COUNTY OF HARNETT RESIDENTIAL LAND USE APPLICATION
Central Permitting 108 E. Front Street, Lillington, NC 27546 Phone: (910) 893-7525 ext:2 Fax: (910) 893-2793 www.harnett.org/permits

PROPERTY LOCATION: Subdivision: Kenlan Farms Lot #: 53 Lot Size: 21,683 sf.
State Road # 250 State Road Name: Shepard Dr. Map Book & Page: 2379 / 637

From: Oliver Tolksdorf [mailto:otolksdorf@harnett.org]
Sent: Monday, January 07, 2013 9:43 AM
To: Gabrielle Zotto
Subject: Kenlan Farms lot 53

PRELIMINARY PLOT PLAN

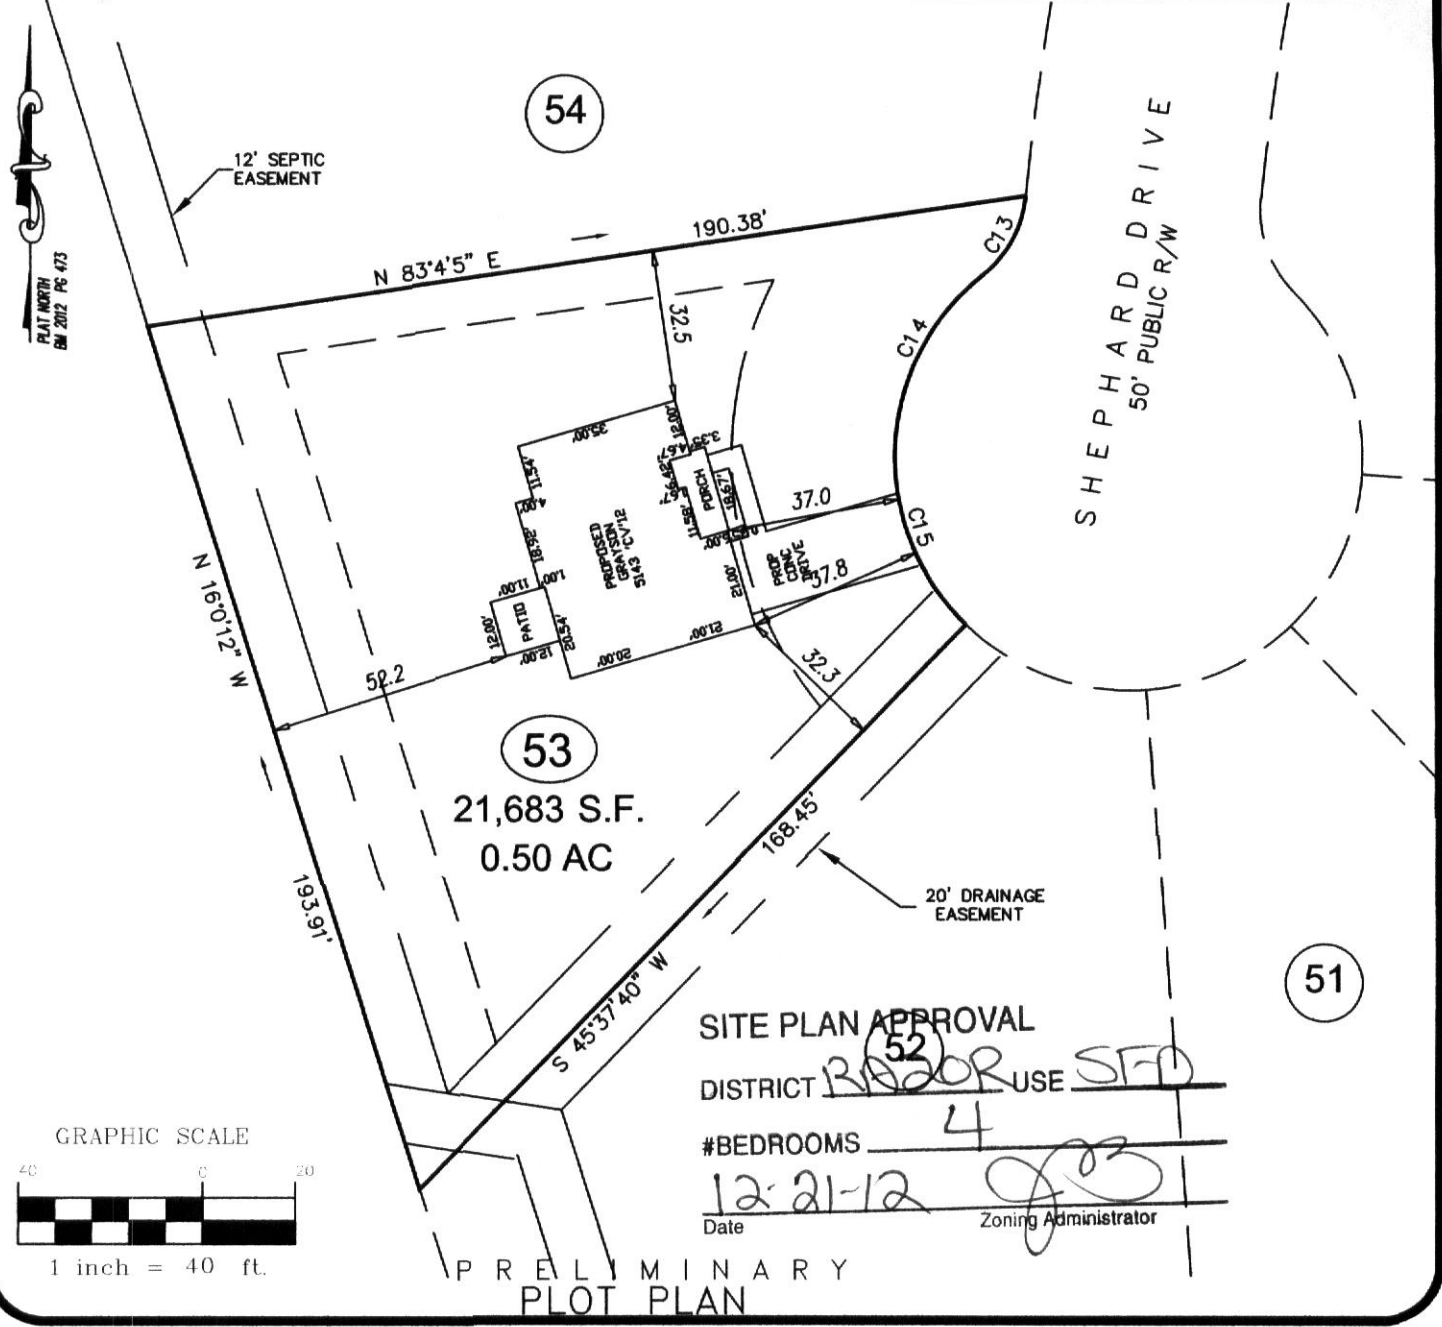
I've looked at lot 53 and there needs to be a few changes to the site plan to make it work. You'll need to flip the house plan to get the driveway to the other side of the house and the entire house footprint needs to slide at least 5 feet towards lot 54. If you can resubmit a new site plan to Central Permitting they'll send it over to me and I can issue a permit on that lot.

REVISION: HOUSE CHANGED TO RH AND MOVED RIGHT 5 PER REQUEST 1-7-13
PLAT NORTH
BM 2012 PG 473
